Submission to SSD-61000021 at 146 Arthur Street, North Sydney

Stockland Corporation Limited (**Stockland**) submits this response to the State Significant Development Application (**SSDA**) for build-to-rent housing that is currently on Public Exhibition at 146 Arthur Street, North Sydney (SSD-61000021). Whilst Stockland supports the transformation of North Sydney with new commercial and residential developments to create a vibrant place, we object to this proposal and urge the Department of Planning, Housing and Infrastructure (**DPHI**) not to support the scheme in its current form. Our objections, as outlined throughout this letter, relate to the following matters:

1 Overall Elevation - North
SCALE 1 : 500

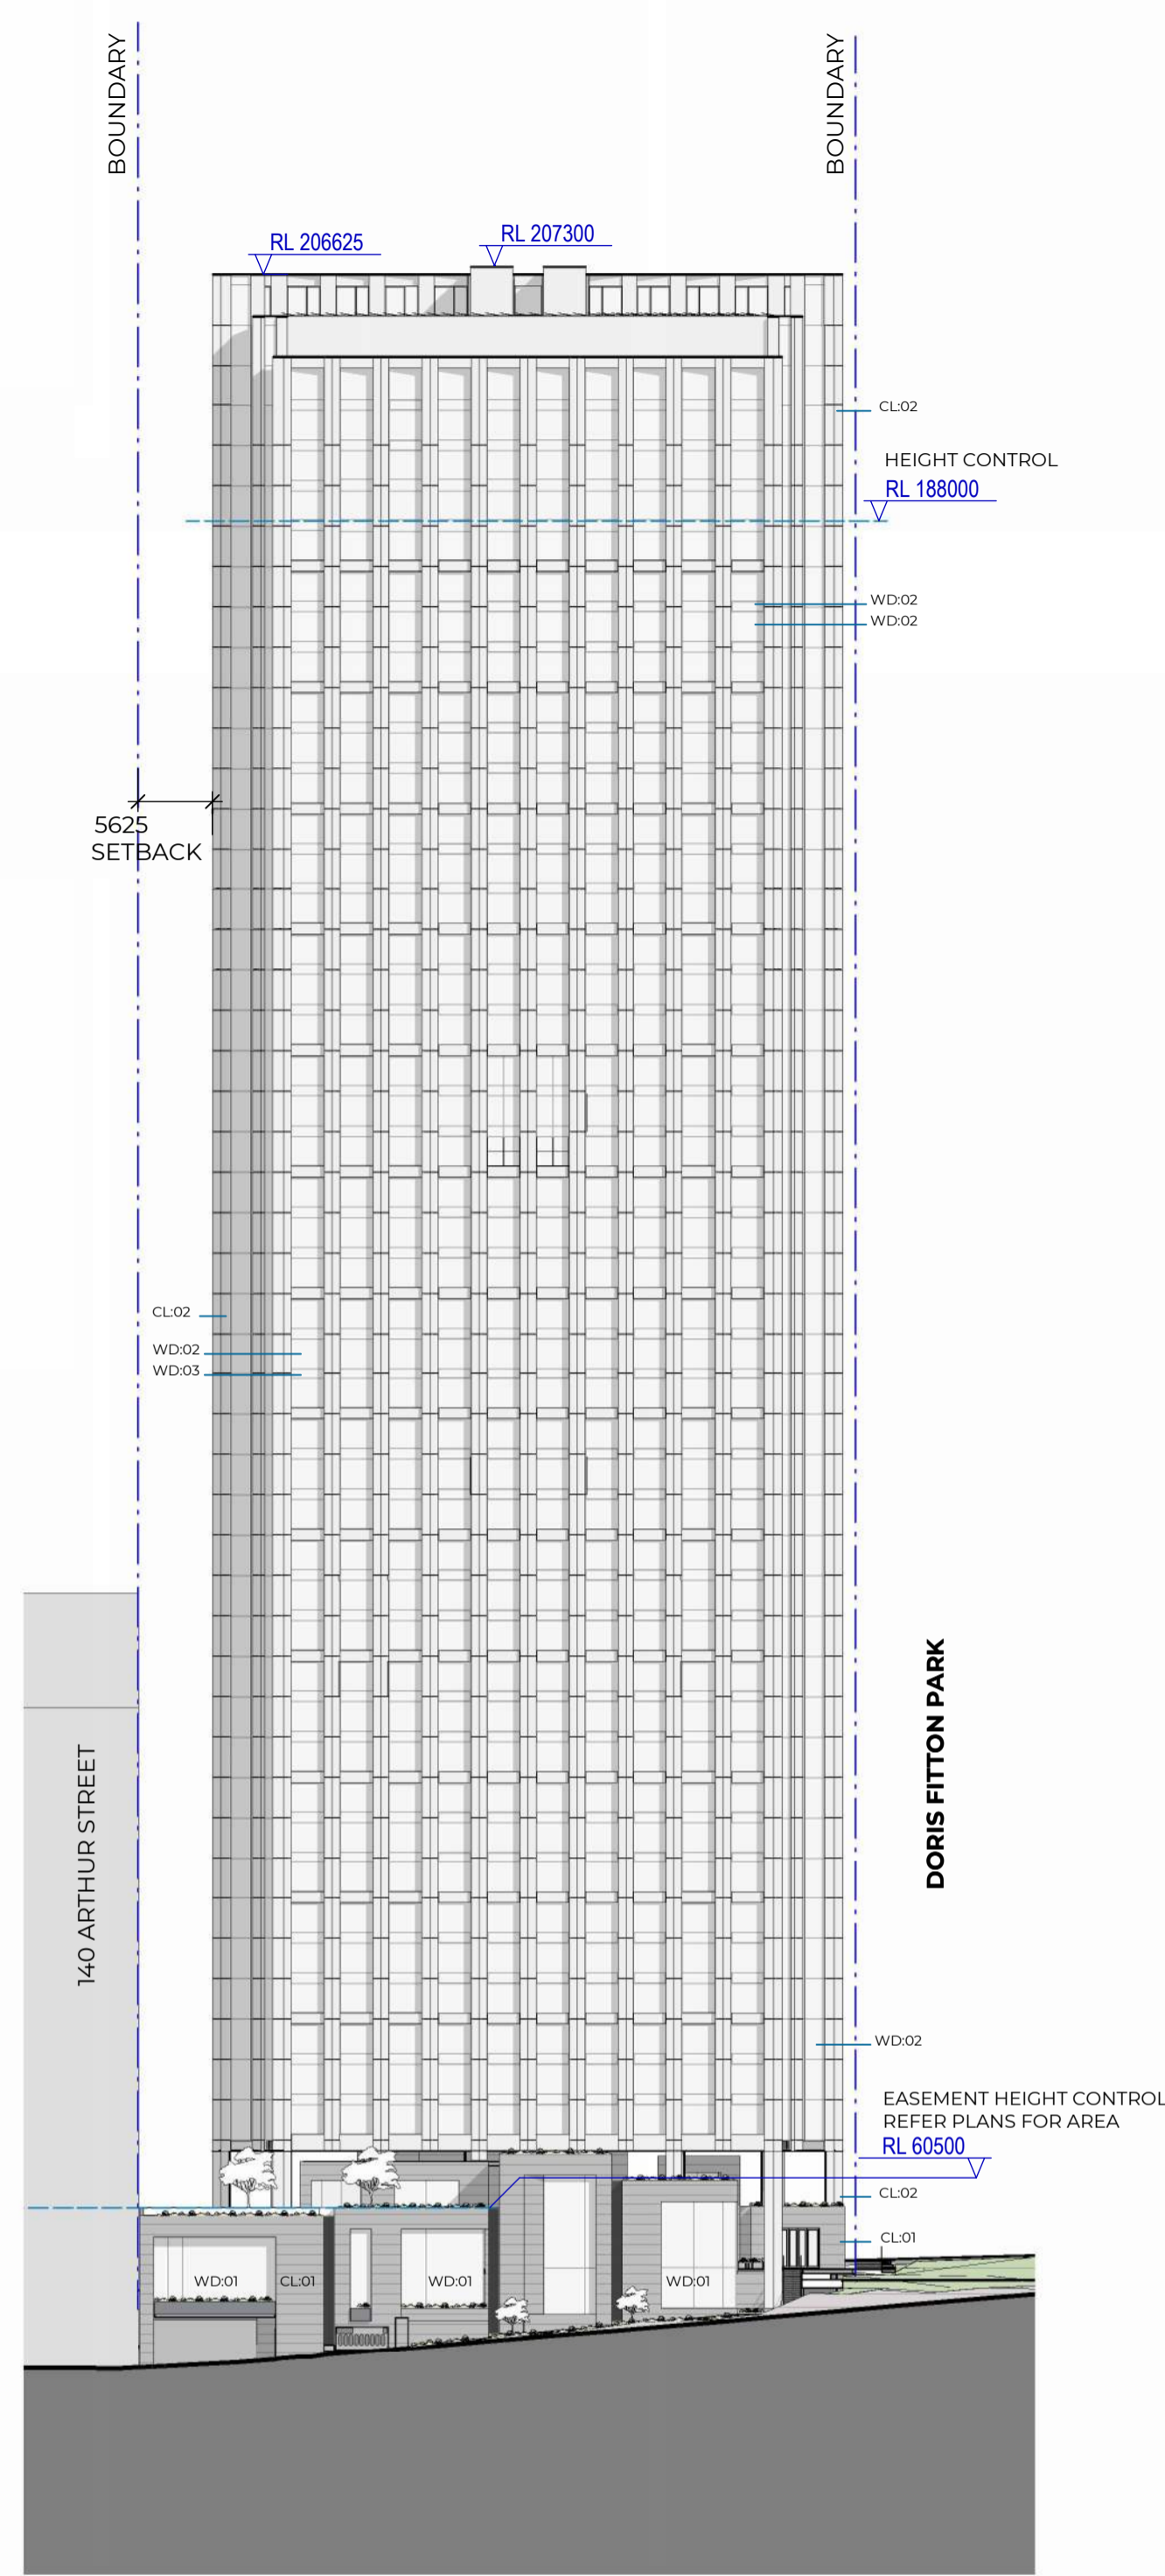
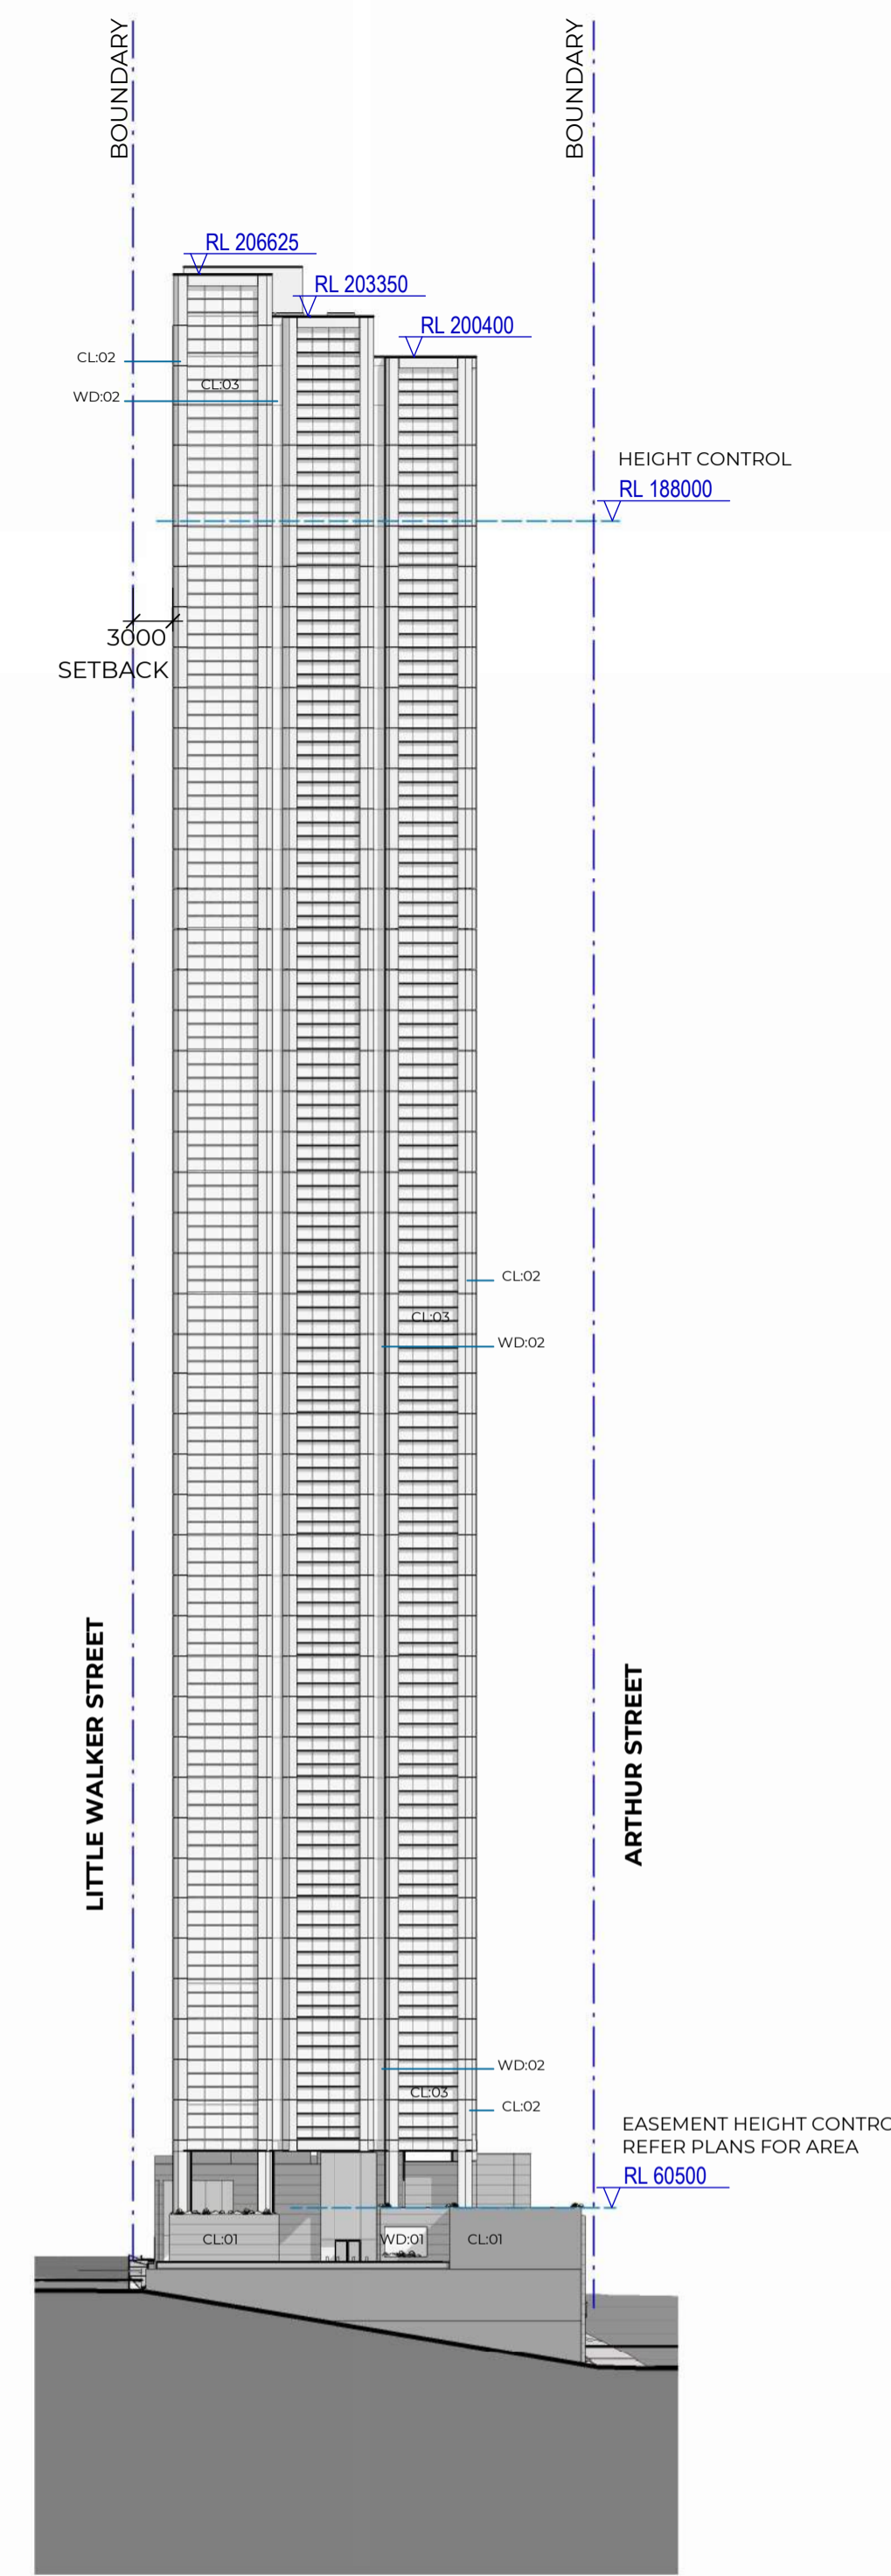
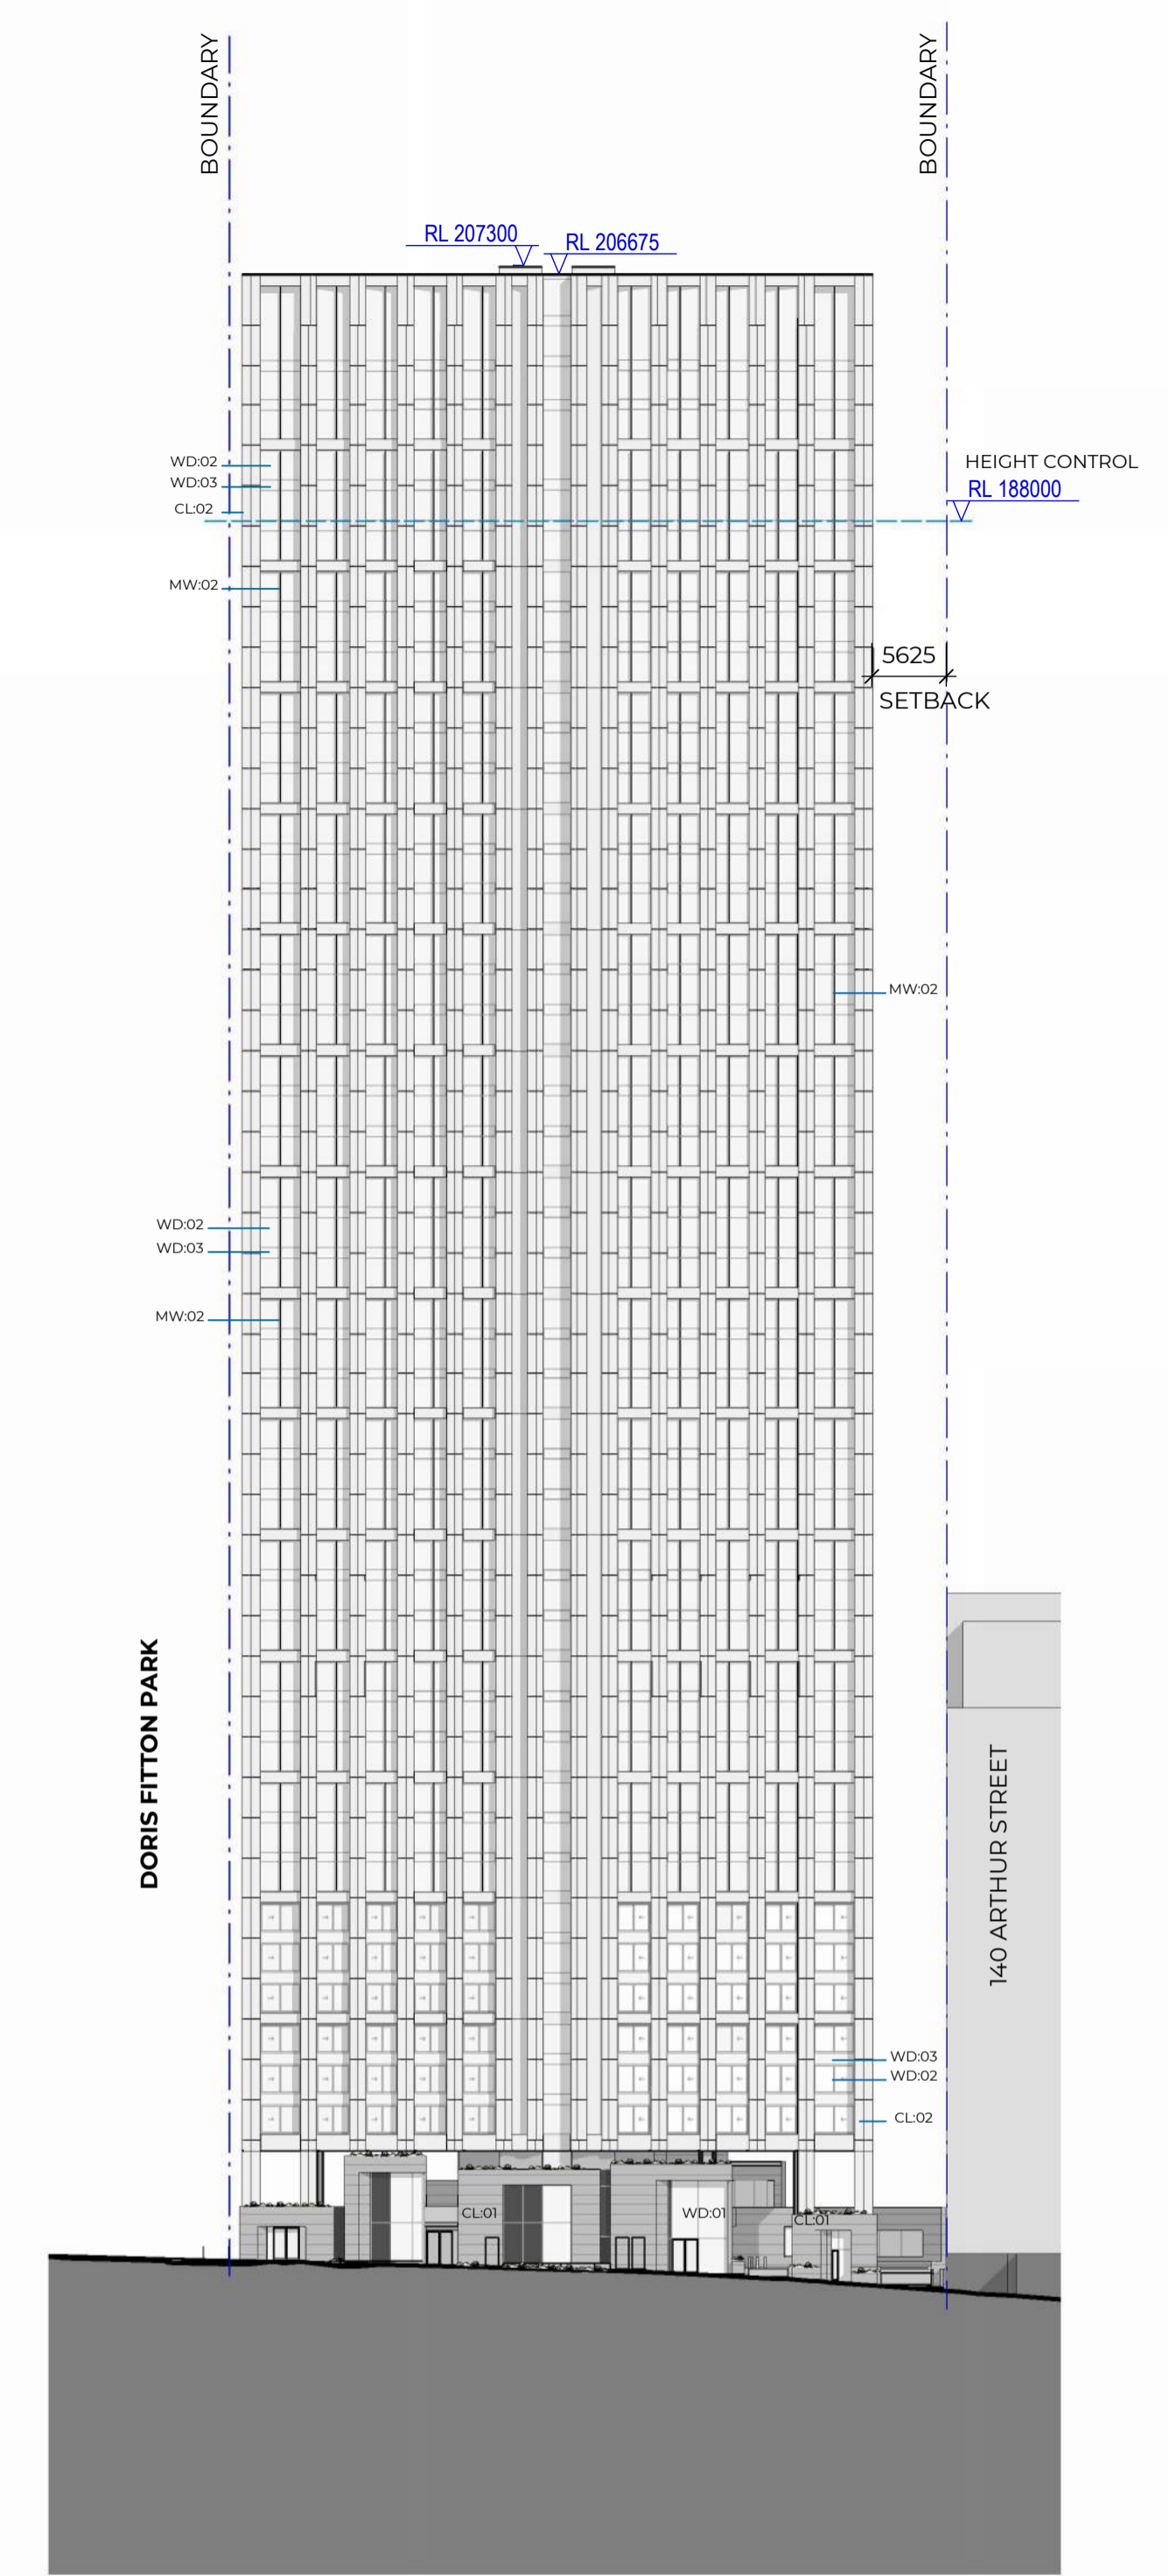
As outlined at **Section 2.2.1**, the proposed tower is inadequately defined as a component that is separate from the podium form. This is largely due to the inadequate above-podium setback distance that has been adopted (3m) along the Little Walker Street frontage. This insufficient built form setback will further emphasise the excessive scale of development, including in relation to the height of the proposed tower form which has not been addressed at street level.

The proposed height of the design scheme for 146 Arthur Street is inconsistent with the established North Sydney skyline. The proposal fails to address the essential urban design principle of tapering building heights as they approach the Warringah Freeway (the eastern boundary of the CBD). The proposed height does not adhere to this fundamental massing principle, noting:

- Adequate setbacks are essential to ensure a smooth transition between podium and tower forms, promoting a harmonious relationship with surrounding buildings. The current design's insufficient setbacks create a bulky and overbearing appearance, disrupting the skyline's balance and cohesion.
- The additional height proposed further aggravates these matters with an exaggerated vertical presence. Rather than enhancing the North Sydney skyline, the proposal detracts from its visual harmony, appearing out of scale and inconsistent with the area's established urban character.
- Successful development must balance height with appropriate proportions, setbacks, and tower separation to create visual rhythm and ensure new projects integrate seamlessly into the broader urban context, contributing positively to the skyline.
